Your Ref: OWPC21080
Our Ref: A/162/18/HH 30-11-2018
Please ask for:
Zac Denton

Town & Country Planning Act 1990 (as amended)
Town & country Planning (Development Management Procedure) (England) Order 2015

Garden outbuilding.
10 Ashurst Way Angmering

REAR ELEVATION

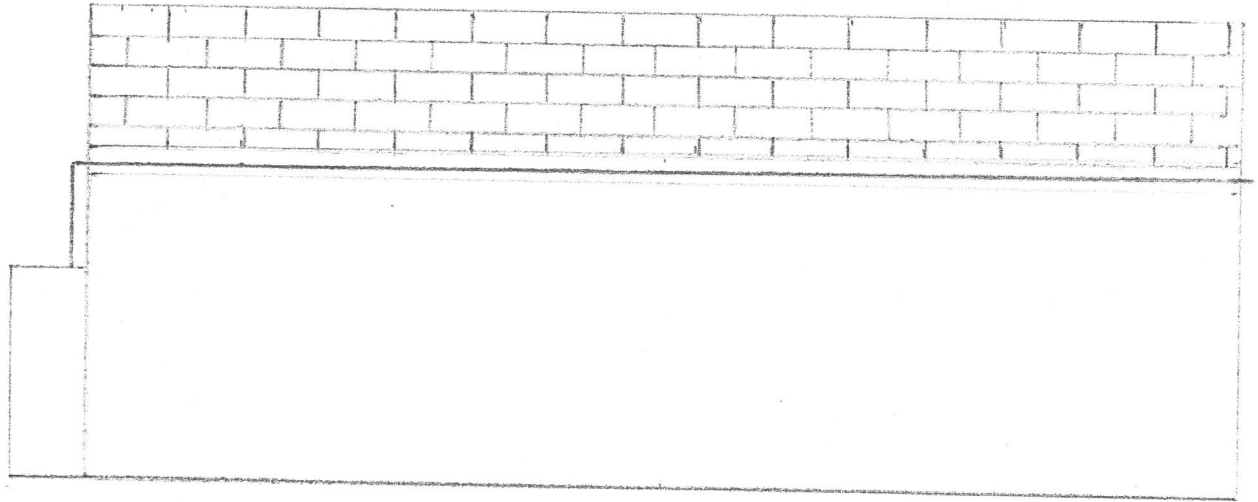
To big and to close to property either side also how are the lilandi trees going to be keep in check cannot go on to rail property to cut them
